STATE OF NORTH CAROLINA  
DEPARTMENT OF TRANSPORTATION

**Addendum No. 1**

RE: Contract ID C203608  
WBS # 8CR. 10761.24, Etc.

US-64 From End Of Albemarle Road To Northern Most Nissan  
Driveway and 22 Sections Of Secondary Roads

TRANSPORTATION MANAGEMENT PLAN

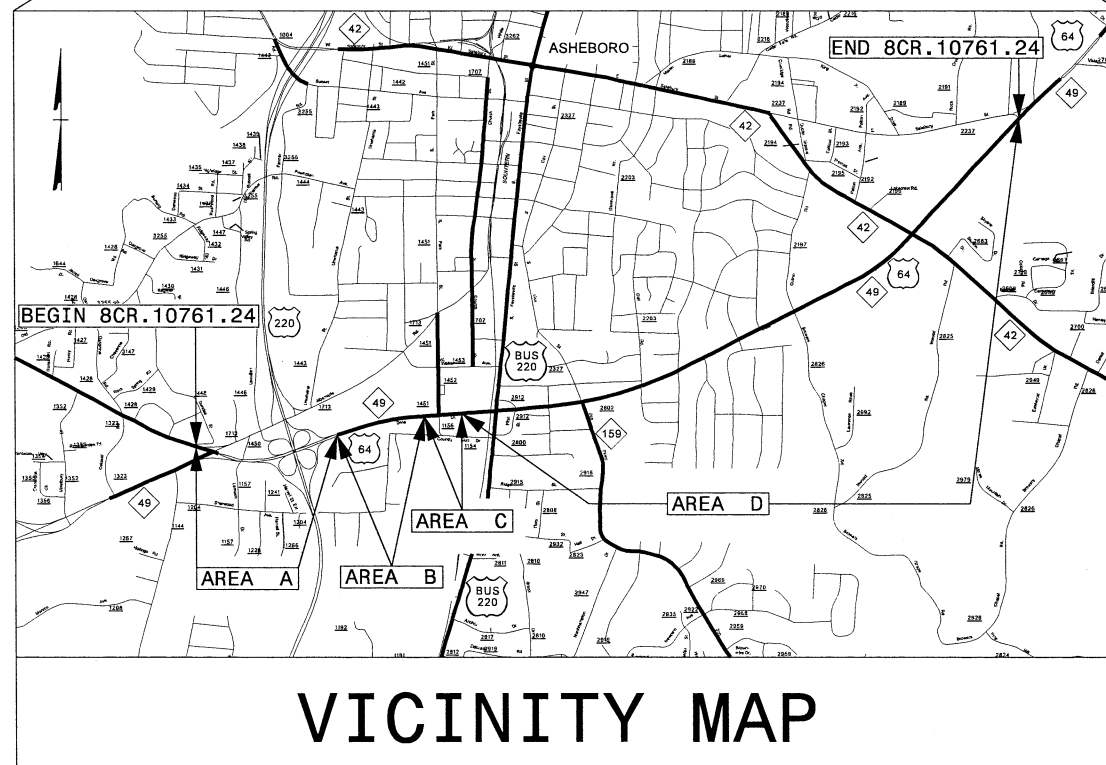
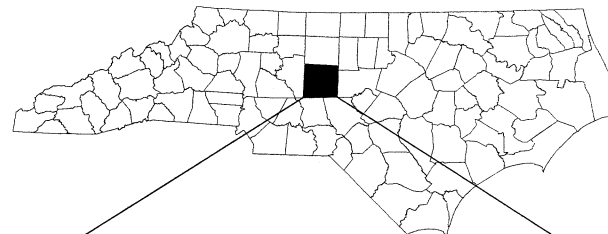
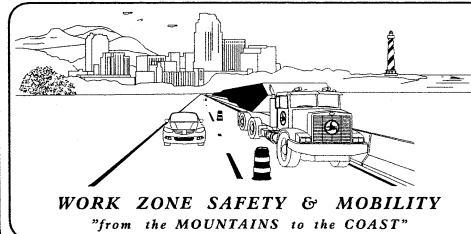
On Sheet No. 12 and New Sheet No. 13 the below noted pay item changes and additions have been made to the "Summary of Quantities". New Traffic Management Plans are being added. In light of these changes we are providing a complete new sketch map package. Please discard the sketch maps you previously received and use the new sketch maps provided.
